Gatwick Airport Northern Runway Project

Examination Ref: TR020005

Joint Local Authorities' Response to the Applicant's Deadline 7 Submissions

Deadline 8: 7 August 2024

**Figure 14: Location of Contractor Compounds**

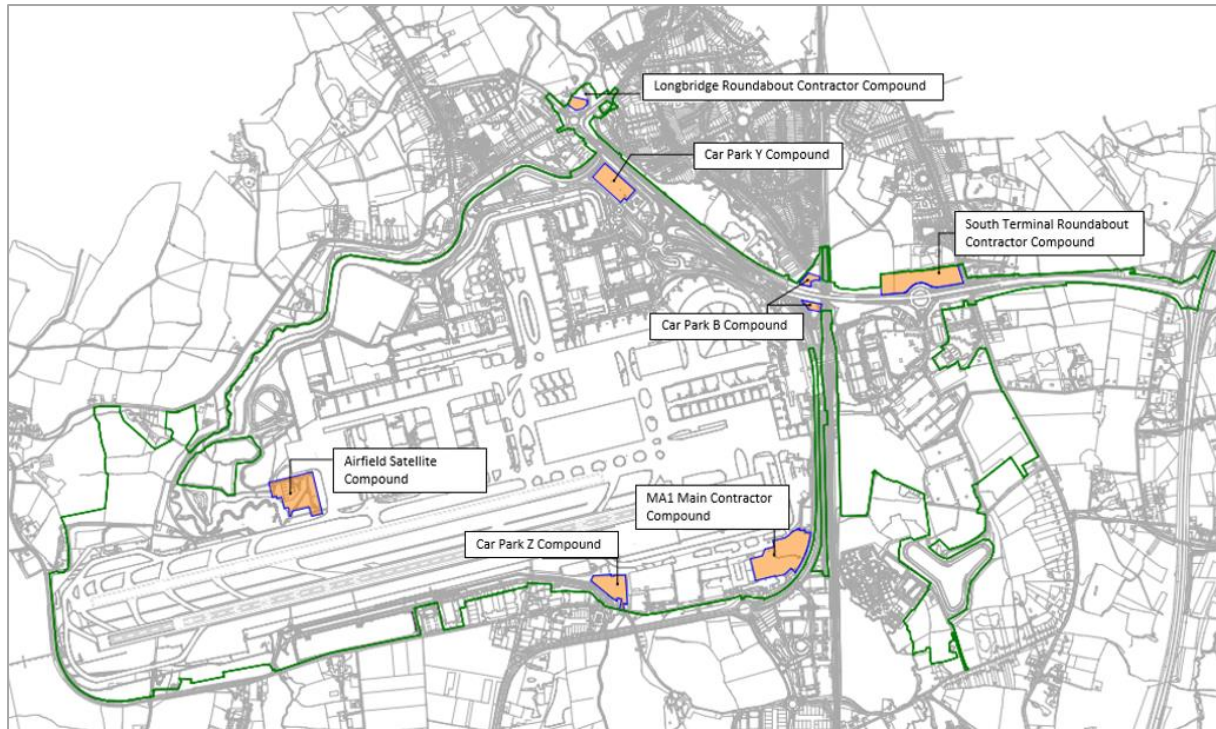
4.6 The level of detail in the document is not considered to provide adequate certainty concerning the visual impacts of these compounds and there is a complete absence of information on the Reed Bed compound. The document would be greatly improved if some layout plans and indicative information found in Volume 5 of the DAS [AS-156] could be included.

- Under paragraph 5.1.2 in their Deadline 6 Submission, entitled, Comments on any further information/submissions received by Deadline 5 [REP6-099], the Highway Authority queried as to whether the Reed Bed Water Treatment Compound should be included in the list of contractor compounds, as a result of Project Change 3. In the Applicant's Response to Deadline 6 Submissions [REP7-095], they state that, the OCTMP shows the location of the main temporary construction compounds which are anticipated to be operational for a number of years, as set out in the Indicative Construction Sequencing [REP2-016]. Given that the temporary construction compound for the water treatment works (reed beds) would only be operational for a short period of time (from 2025 to 2026), it has not been listed in the OCTMP. The Highway Authority are of the view that this should be made clear in paragraph 5.1.2 of the OCTMP that these are just the main construction compounds and that others may be required. Presently that is not the case, as it is in the Code of Construction Practice Version 4 (Tracked) [REP7-023]. Paragraph 4.5.8 of REP7-023 states, "*In addition, a number of temporary compounds may be erected to support specific construction activities.*" A similar statement should be made in Section 5 of the OCTMP.
